**Town & Country Planning Act 1990 (as amended)
Town and Country Planning (Development Management Procedure) (England) Order 2015
Application for Planning Permission**

Development New access from New Barn Lane to Land West of New Barn Lane & relocation of 5 No. existing parking spaces.

Location Land West of New Barn Lane Bersted

Name	Date	Scale 1:2500 @ A3	
Drawn	AGA	16/03/18	File No. A13395-T-004 - Site Boundary - revC.dwg	
Designed	AGA	16/03/18	Drawing Status	
Checked	DW	16/03/18		
Approved	PDS	16/03/18		
Drawing No.			A13395-T-005	
			Revision C

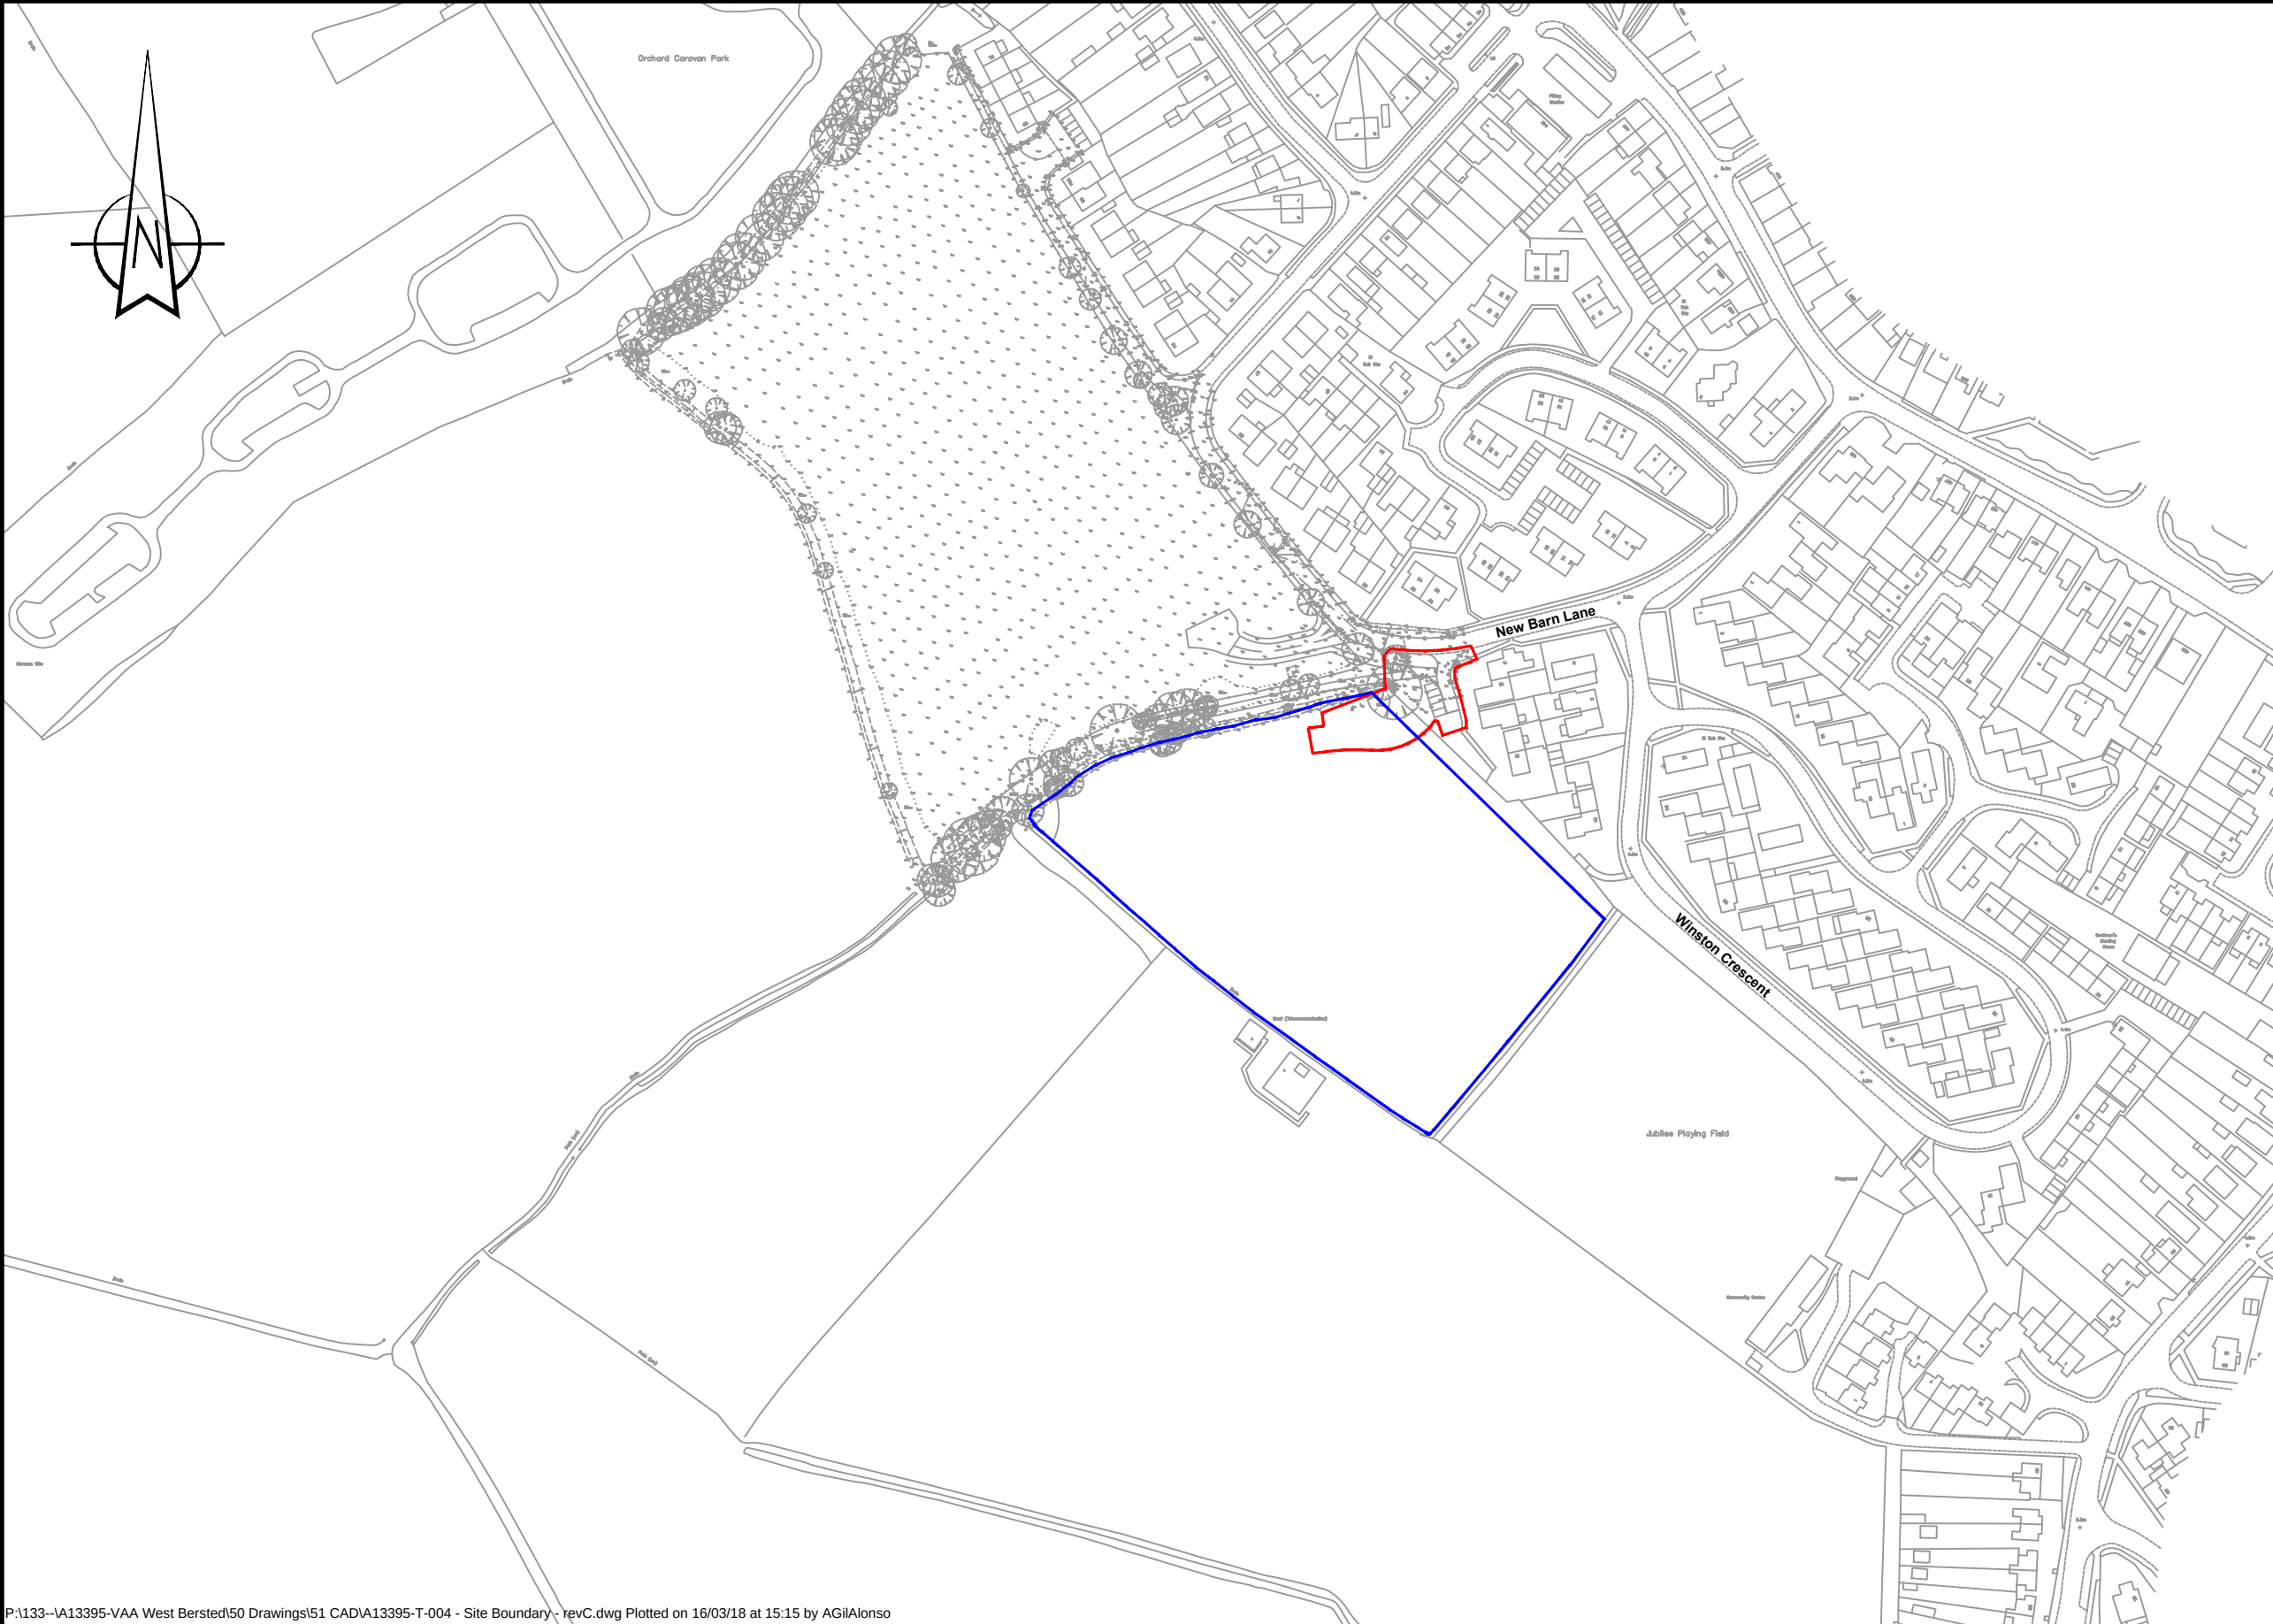
Please provide two named roads on the Red Line Plan and the Block Plan and return accordingly.
